Sent: 19 January 2012 11:10  
To: Planning  
Subject: Comments Added: 42 Theobalds

Application ID: S6/2011/2856/FP Ms J Philips Application Owner: Welwyn & Hatfield Borough Council(Development Control Officer)

Location: 42 Theobalds

Description: Erection of single storey rear extension, alterations to roof to include; hip to gable conversion at rear of roof, formation of loft conversion and insertion of 4 dormers windows Comment Added:

DRWG: SIDE ELEVATIONS  
PROPOSED

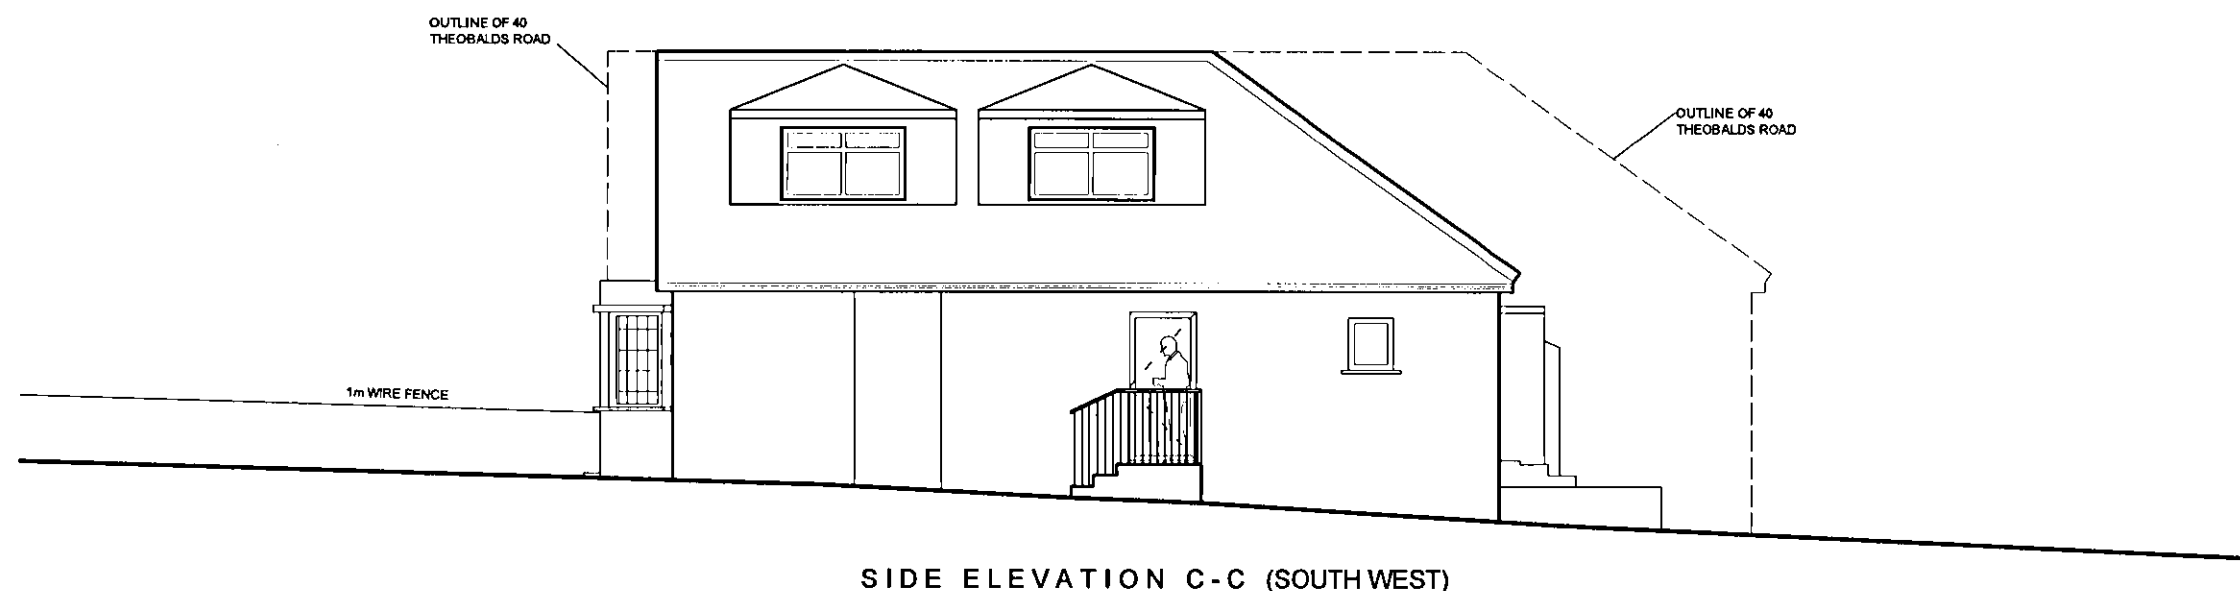
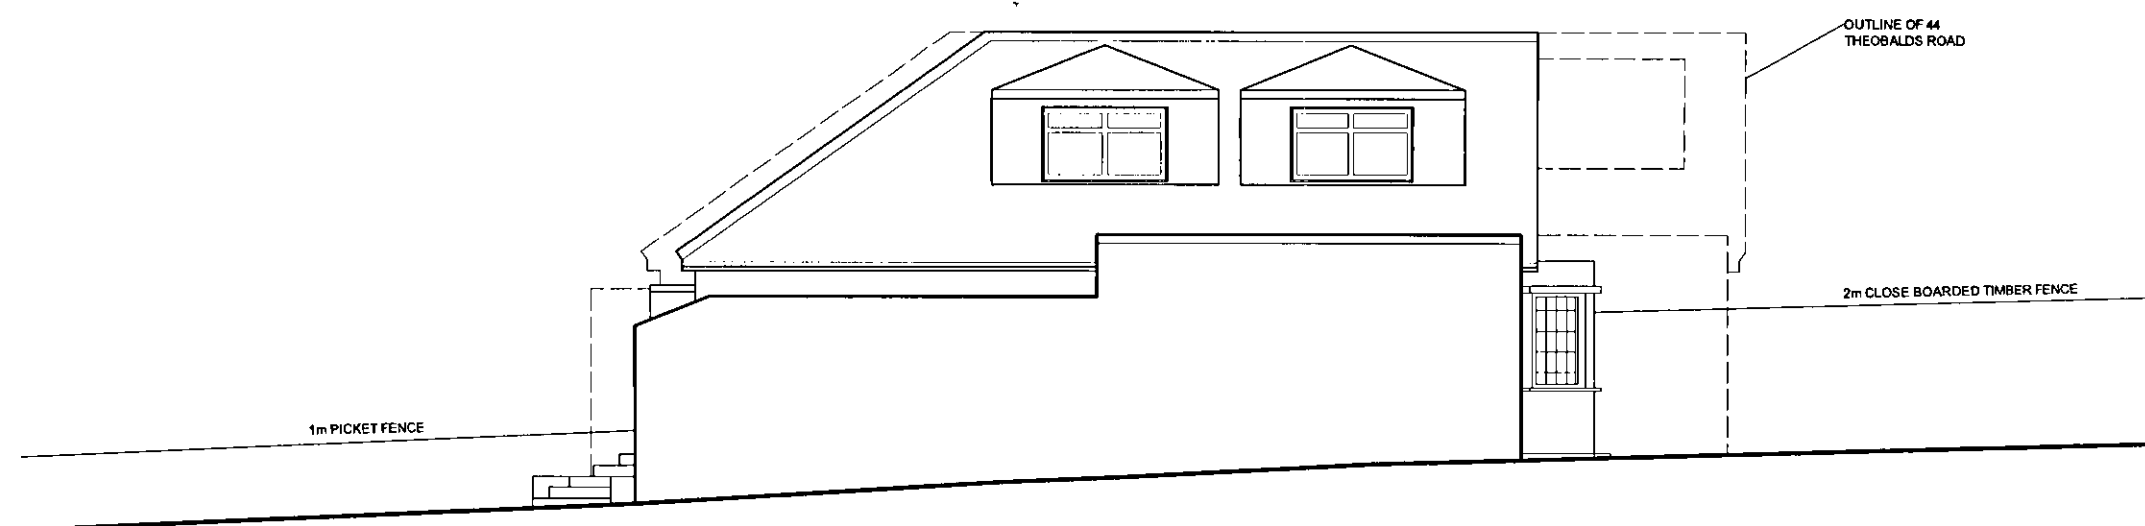
Comment: The Pc have concerns that the dormer side windows may create an issue of overlooking.
